## MEMORANDUM

**To:** FILE  
**From:** Jean Fraser  
**Subject:** Application ID: 2015-058  
**Date:** 7/9/2015

**Comments Submitted by: Keith Gautreau/Fire on 5/6/2015**

**From:** Keith Gautreau  
**To:** Errico Thomas; Jean Fraser  
**Date:** 5/12/2015 11:17 AM  
**Subject:** Re: 1342 Congress- Neigh Center 2015-058

C-2B

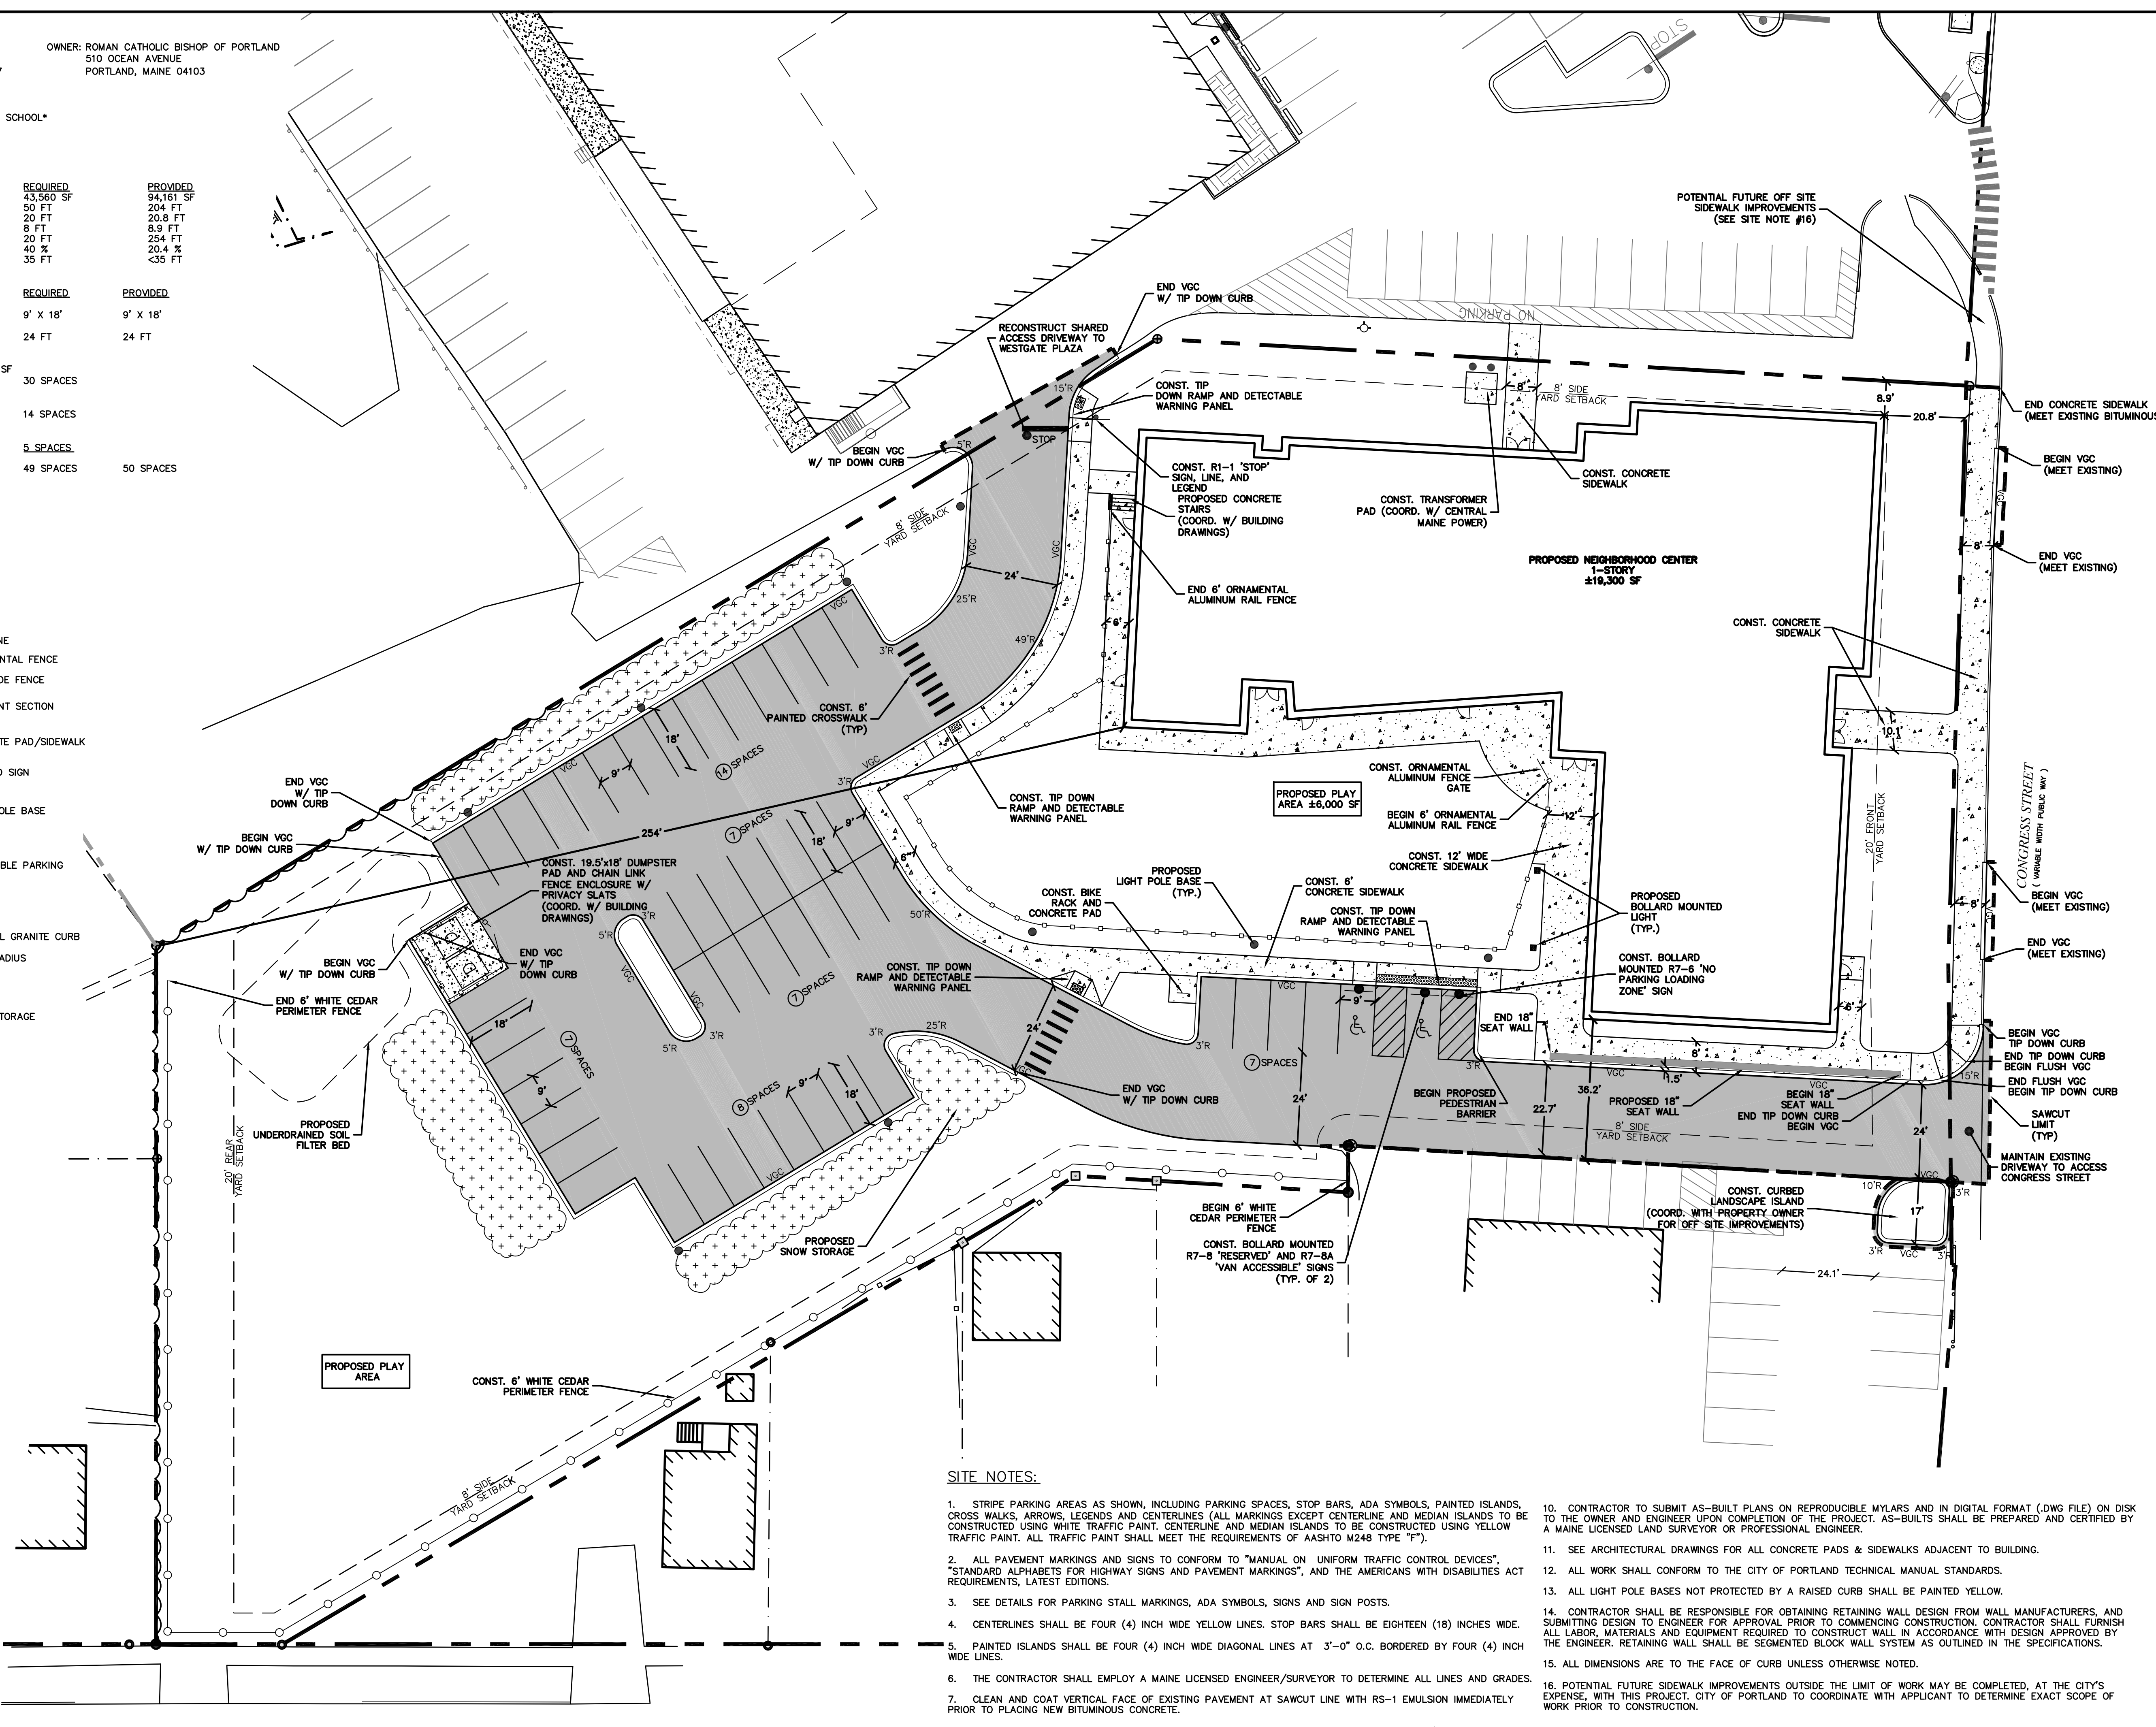
1.)Largest Fire Department Vehicle must be able to navigate through the parking lot to access building.

2.)Fire Department Access shall have an unobstructed vertical clearance of not less than 13 ft 6 in.

I am good with the turning radius plan that has been provided. It's not my area of expertise but I agree that would be a significant safety issue with cars stopping on Congress St. (especially during rush hour)

The final plans have met the conditions in regards to access, water supply and construction.
